STATE OF NORTH CAROLINA
DEPARTMENT OF TRANSPORTATION

June 27, 2005

SUBJECT: **Permit Modification Request for TIP No. R-2417BB**, Lee County, US 421/NC 87 Bypass from East of SR 1521 to east of NC 42, Federal Aid No. STP-NHF-421(2), State Project No. 8.T540402, NCDOT Division 8, \$475 Debit WBS Element 34431.1.1.

PROJECT REFERENCE NO.	SHEET NO.
R-2417BB	2AJ
RW SHEET NO.

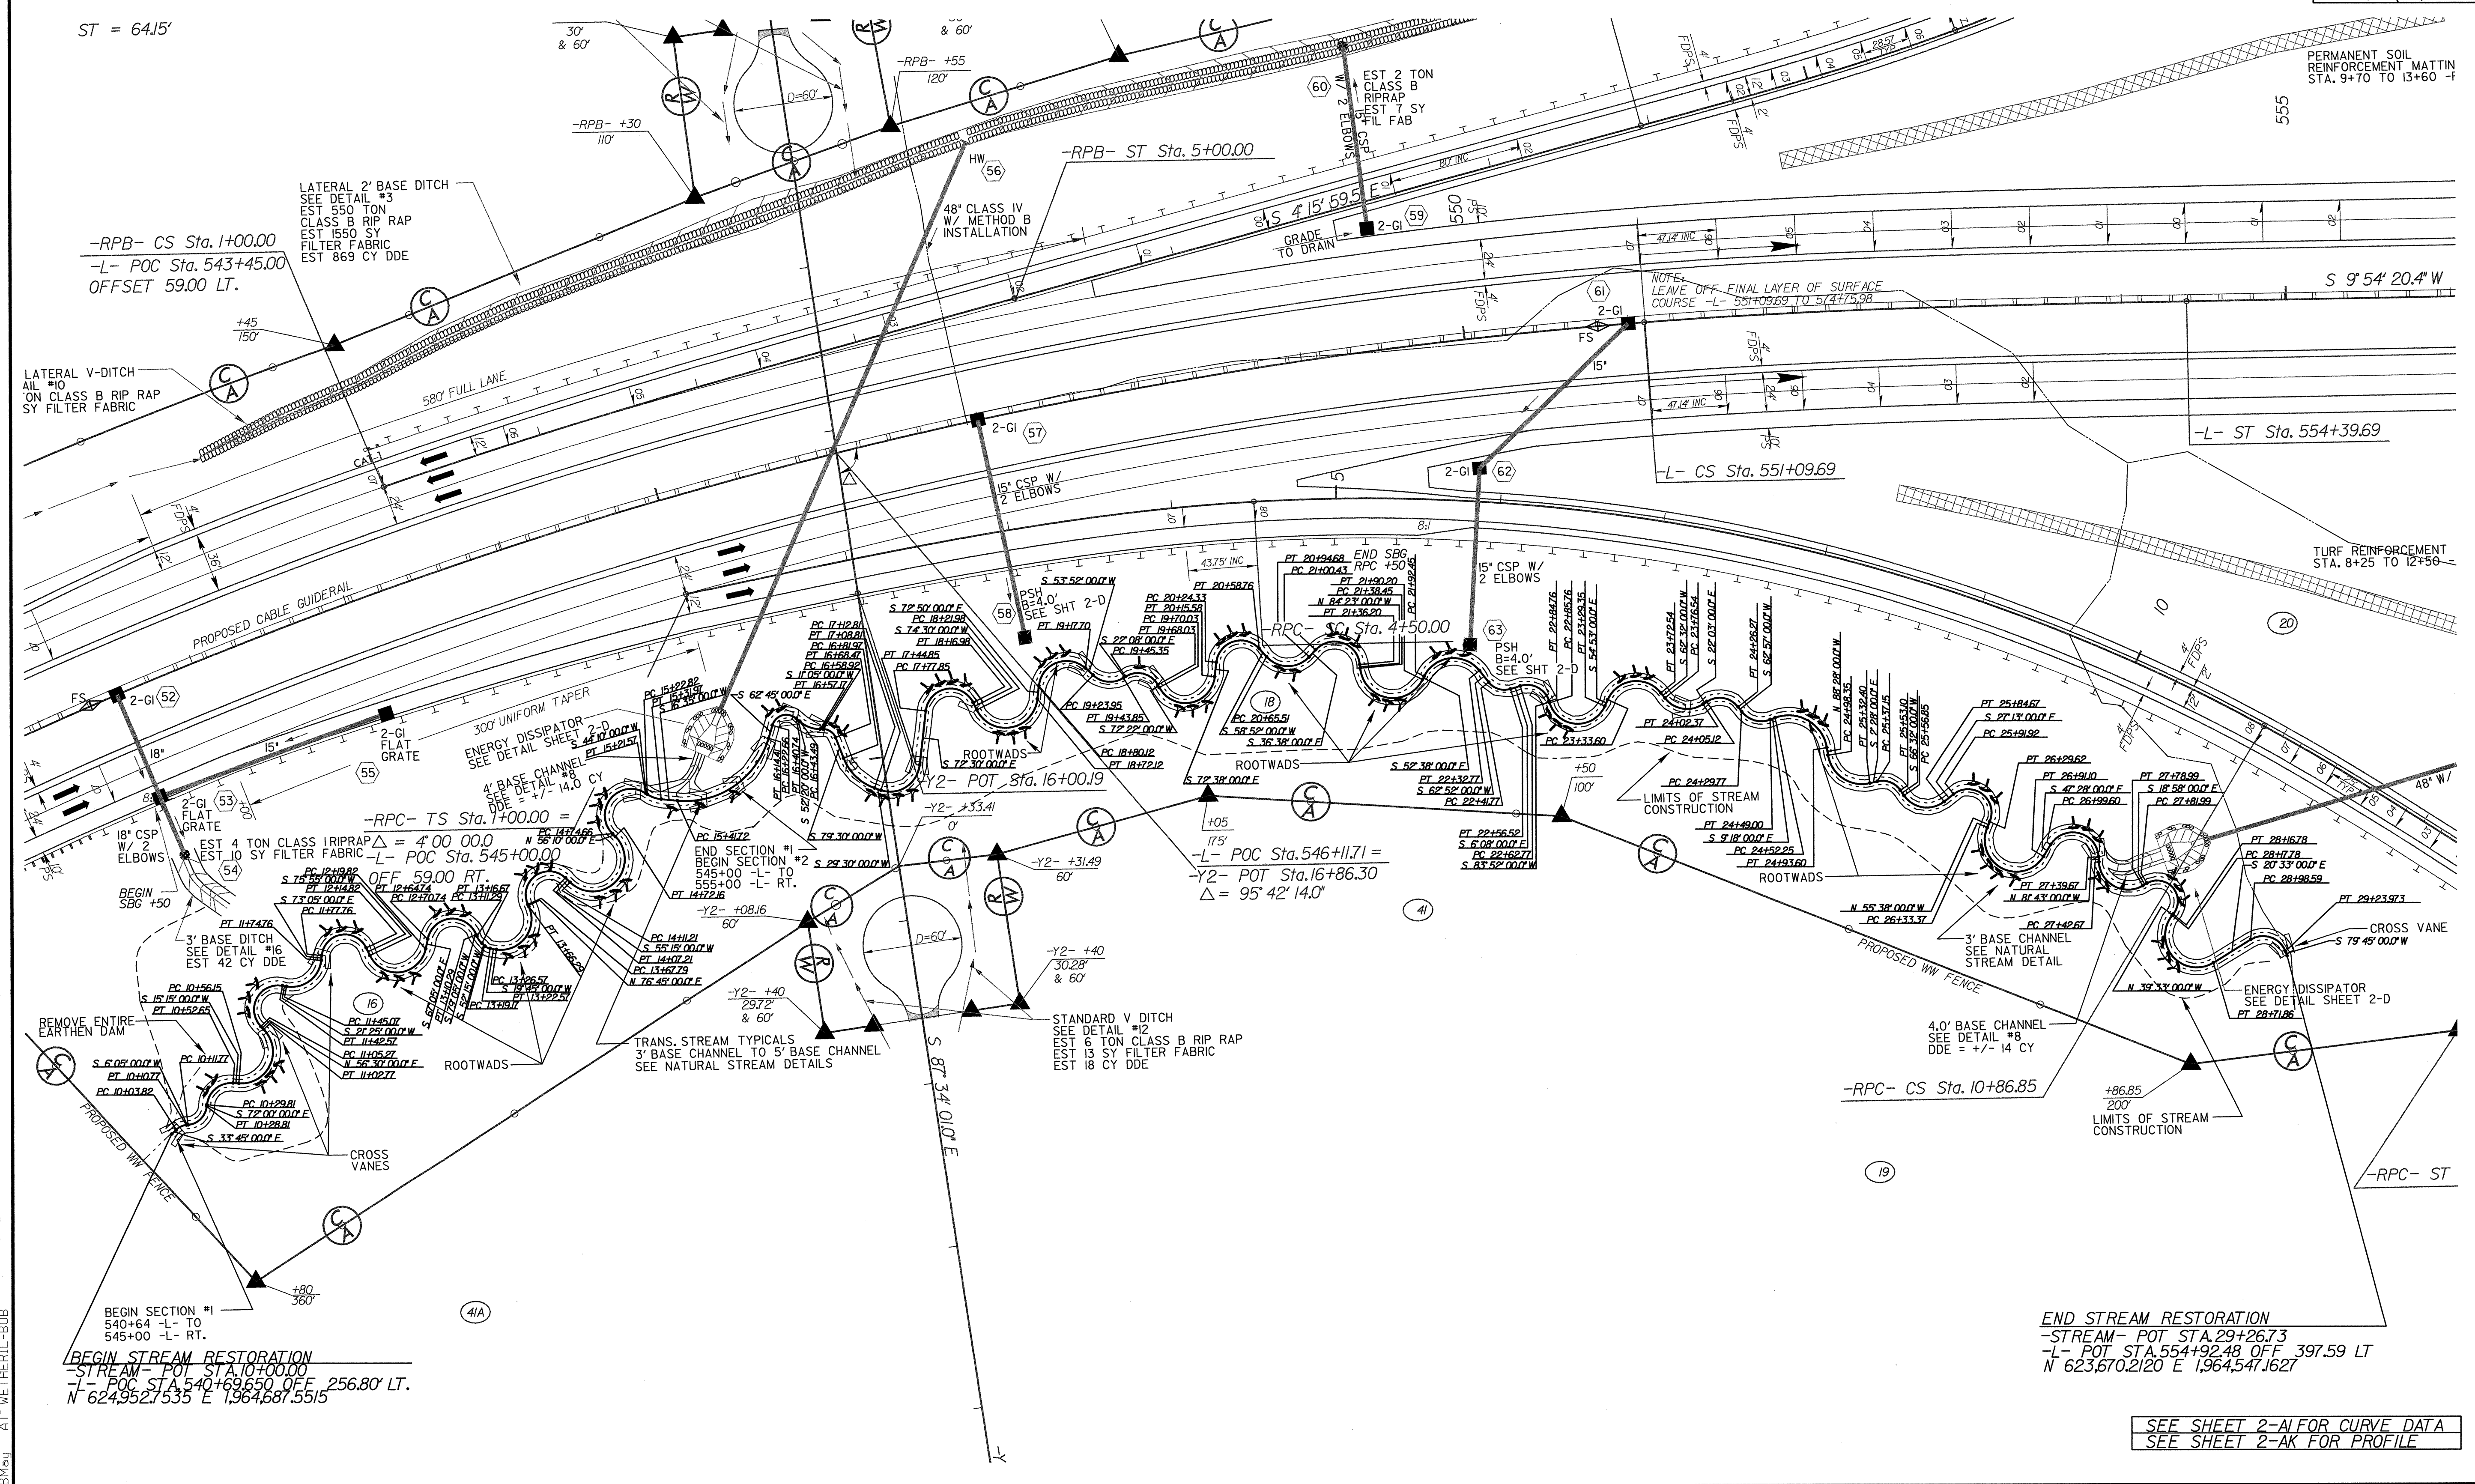
The purpose of this letter is to request modifications to the Clean Water Act (CWA) Section 404 Permit issued by the USACE and the 401 Water Quality Certification issued by the NCDWQ. This modification addresses the revision to the natural stream design of the stream used for stream impacts at Site 6, and provides confirmation of mitigation by the EEP for the associated loss of 190 feet of natural stream design. Revised Plan Sheets 2AI, SAJ, and 2AK, and a new Detail Sheet are attached.

The North Carolina Department of Transportation (NCDOT) proposes a revision to the natural stream design for the stream relocation used for stream impacts at Site 6. A portion of the stream has been redesigned from a Rosgen type "C" channel to a Rosgen type "B" channel. The need for this redesign is due to this section of stream being located

along a drained pond bottom that is on a 7% slope. The "B" type channel design being incorporated in this modification utilizes more gradient control structures and less sinuosity than the originally permitted "C" type design. This redesign has resulted in a 190-foot loss of natural stream design, reducing the permitted 1,924 feet of natural stream design to 1,734 feet. In support of this permit modification request, the NCDOT has received confirmation from the North Carolina Ecosystem Enhancement Program (EEP) that they will be providing compensatory mitigation for the associated 190-foot loss of natural stream design (letter attached).
